CITY OF ALBUQUERQUE

April 19, 2023

Re: NuVue- 6th and Cutler
2300 6th St. NW
Traffic Circulation Layout
Engineer's/Architect's Stamp XX-XX-XX (H14-D117)

Based upon the information provided in your submittal received 03-27-23, the above referenced plan cannot be approved for Building Permit until the following comments are addressed:

TRAFFIC CIRCULATION
PLAN

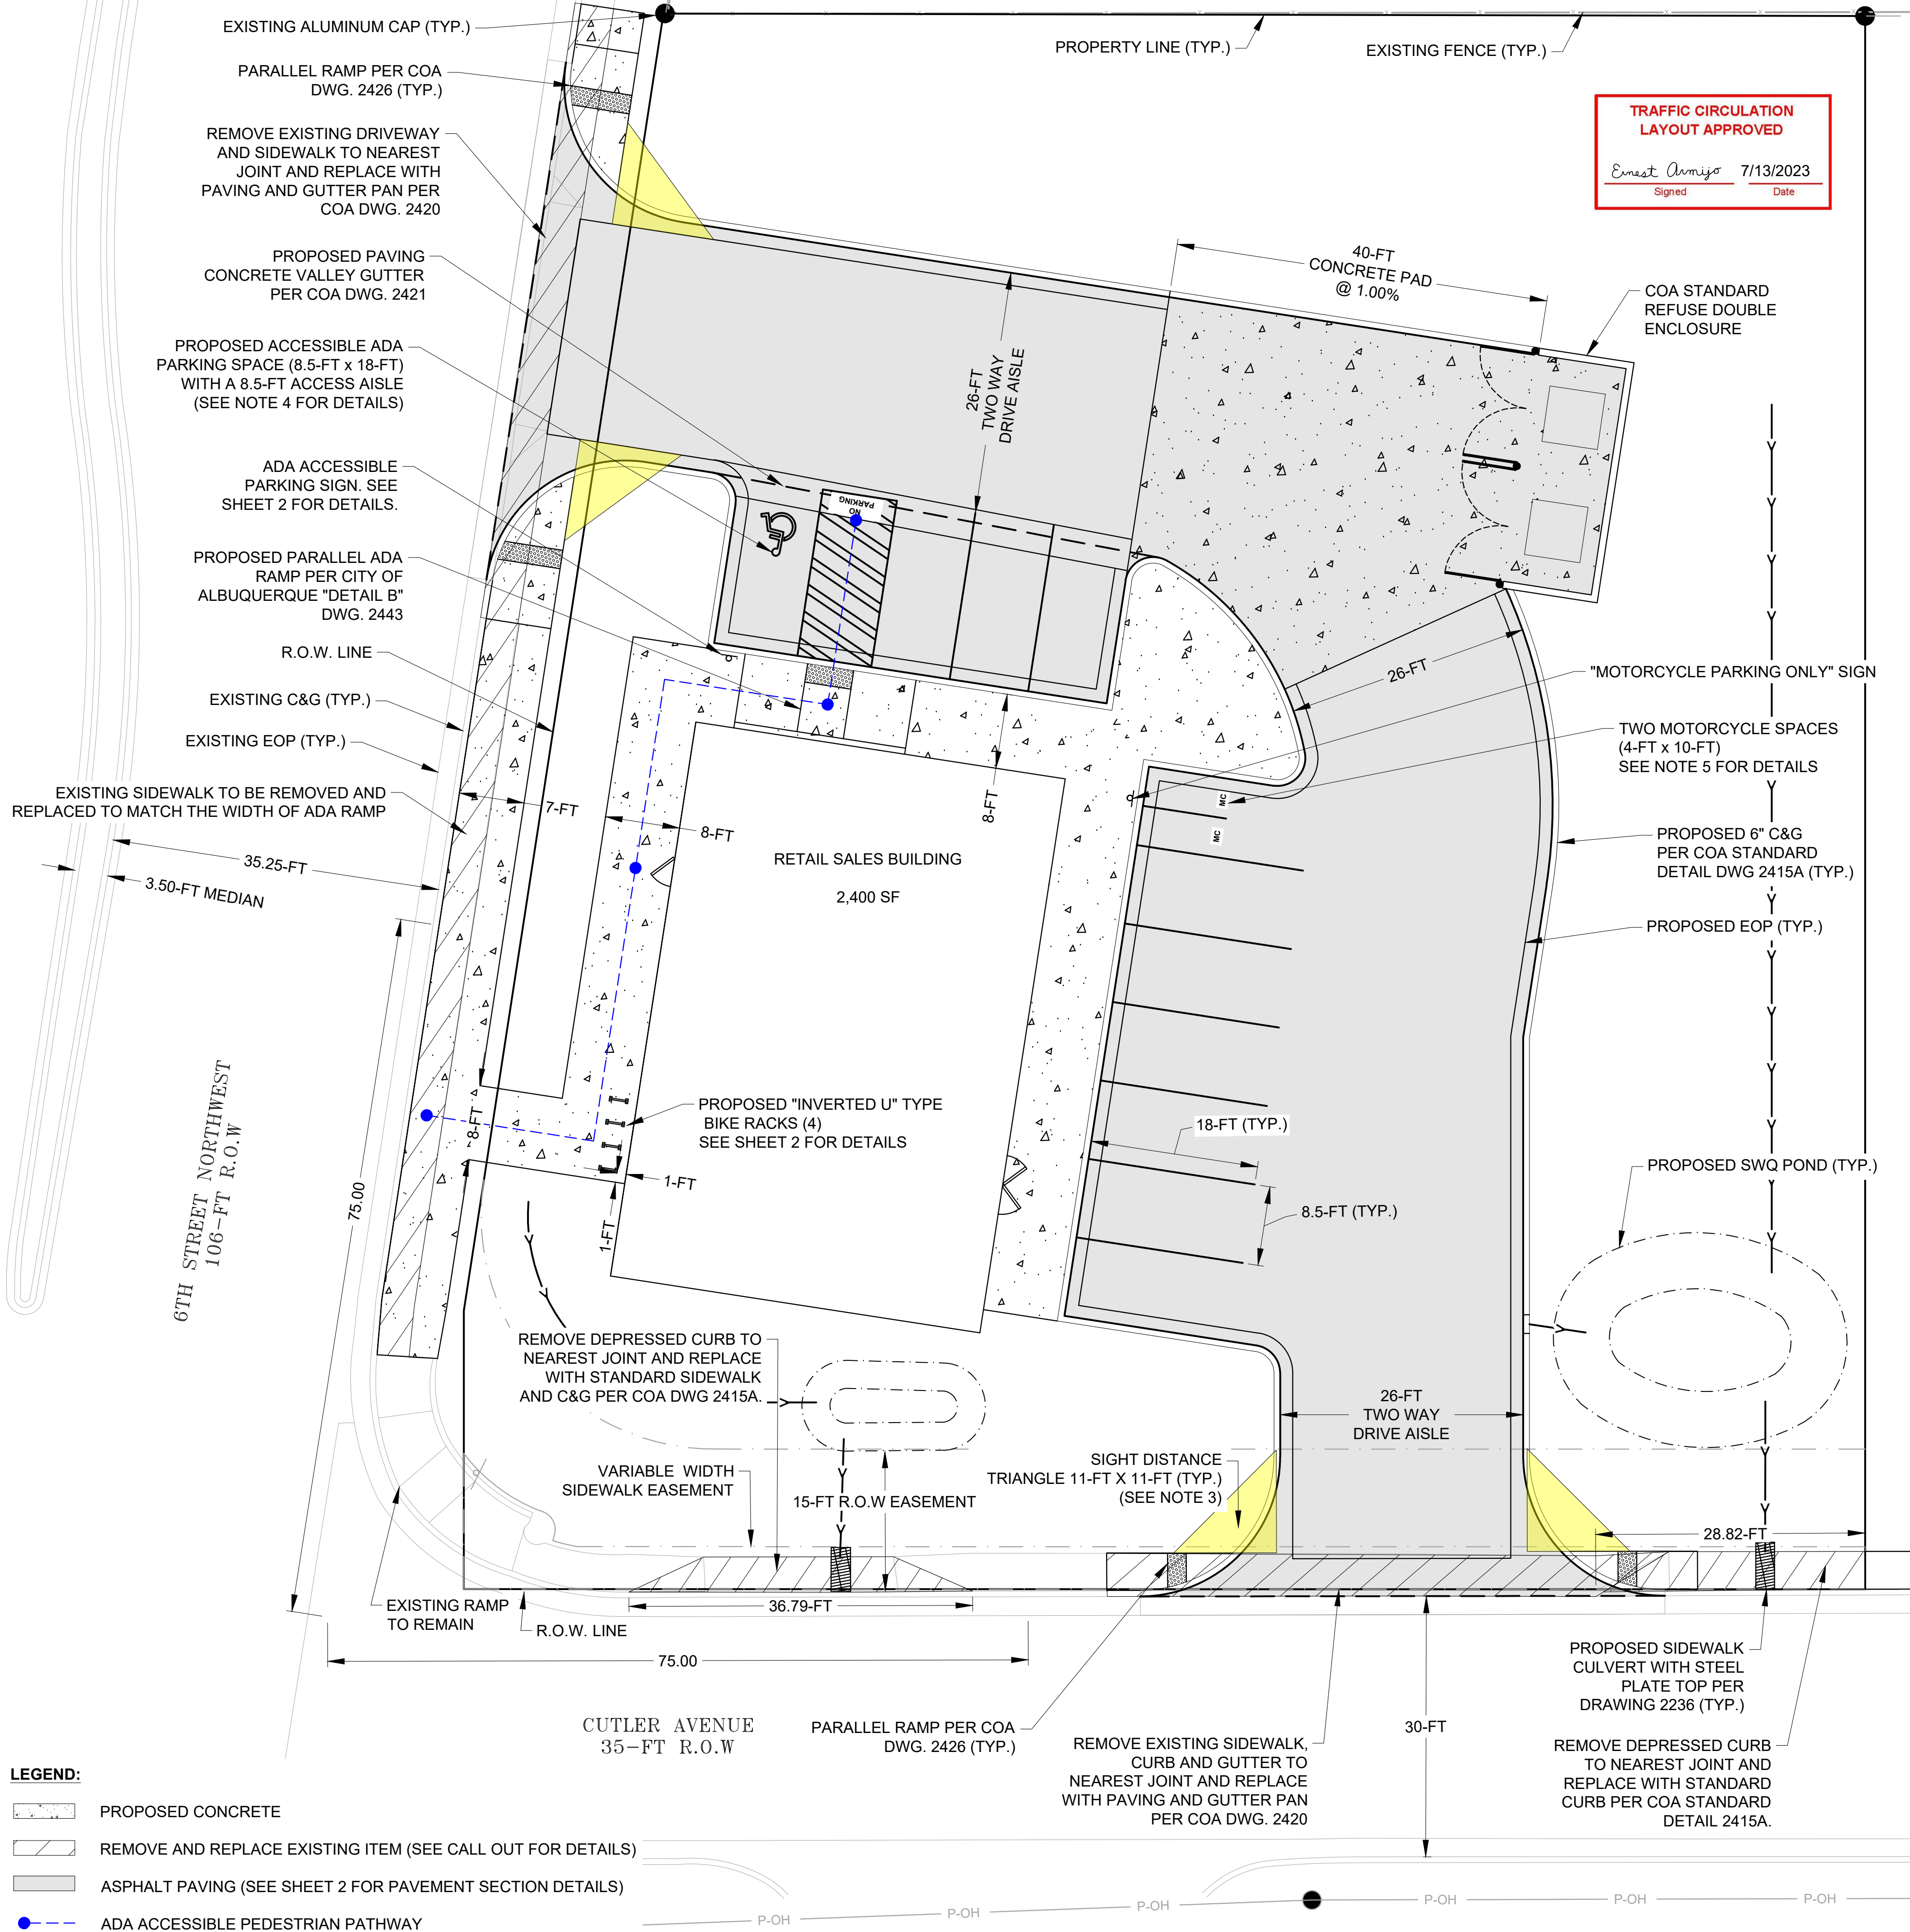
1. The traffic circulation layout must be stamped, signed, and dated by an engineer or architect licensed in the state of New Mexico.
2. Identify all existing access easements and rights of way width dimensions.

3. Identify the right of way width, medians, curb cuts, and street widths on 6th St. and on Cutler Ave.
4. Please define the property line around the site. It appears that the property line at the south side of the site located on the curb (on the front of the sidewalk). If so, please provide sidewalk easement. For sidewalk easement please contact at **Carrie Mouck** DRC Contract Specialist ☎ 505.924.3996 e camouck@cabq.gov

5. Site access off 6th St. must be modified to current ADA standard. Please provide details.
6. The minimum distance from the site access off Cutler to the intersection of Cutler and 6th St. should be 75 ft. Please show this dimension on the site plan.

7. Please provide details for the proposed drivepad off Cutler Ave. and reference COA std dwg.
8. The ADA accessible spaces must include an access aisle. Van accessible aisles should be 8ft wide; all others should be 5ft wide.

9. The ADA accessible parking sign must have the required language per 66-7-352.4C NMSA 1978 **"Violators Are Subject to a Fine and/or Towing."** Please call out detail and location of signs.

10. The ADA access aisles shall have the words **"NO PARKING"** in capital letters, each of which shall be at least one foot high and at least two inches wide, placed at the rear of the parking space so as to be close to where an adjacent vehicle's rear tire would be placed. (66-1-4.1.B NMSA 1978)

11. Please provide details for all the proposed signage (ADA and Motorcycle) and Bike Rack.

12. Motorcycle parking spaces shall be designated by its own conspicuously posted upright sign, either free-standing or wall mounted per the zoning code.

13. The pavement marking "MC" should be shown in the opposite direction for Motorcycles entering the parking space.
14. All bicycle racks shall be designed according to the following guidelines:

18. A 5 ft. keyway is required for dead-end parking aisles.
19. Per the IDO, a 6 ft. wide ADA accessible pedestrian pathway is required from the public sidewalk to the building entrances. Please clearly show this pathway and provide details.

20. Per DPM, a 6 ft. wide ADA accessible pedestrian pathway is required from the ADA parking stall access aisles to the building entrances. Please clearly show this pathway and provide details.

21. ADA accessible pedestrian pathway should not be placed behind parking space or adjacent to a vehicular way. Vehicle and pedestrian/wheel chair conflicts should be avoided as much as possible.

22. All sidewalks along streets should be placed at the property line.
23. Curbing should be installed to delineate landscape, parking, and pedestrian ways and identify points of access. Please call out detail and location of barrier curb.

24. Parking areas shall have barriers to prevent vehicles from extending over public sidewalk, public right-of-way, or abutting lots.
25. Refuse vehicle maneuvering shall be contained on-site. The refuse vehicle shall not back into the public right of way.; provide a copy of refuse approval.

26. Please provide a copy of Fire Marshal approval.
27. It is not apparent what type of pavement surface is being proposed. A hard driving surface will be required as part of this proposed project for parking area and drive aisles.

28. Show the clear sight triangle on both site accesses and add the following note to the plan: "Landscaping and signage will not interfere with clear sight requirements. Therefore, signs, walls, trees, and shrubbery between 3 and 8 feet tall (as measured from the gutter pan) will not be acceptable in the clear sight triangle.

29. Please specify the City Standard Drawing Number when applicable.
30. Please add a note on the plan stating "All improvements located in the Right of Way must be included on the work order."

31. Unused curb cuts must be replaced with sidewalk and curb & gutter. A build note must be provided referring to the appropriate City Standard drawing.

32. Add a note stating "All broken or cracked sidewalk must be replaced with sidewalk and curb & gutter." A build note must be provided referring to the appropriate City Standard drawing.
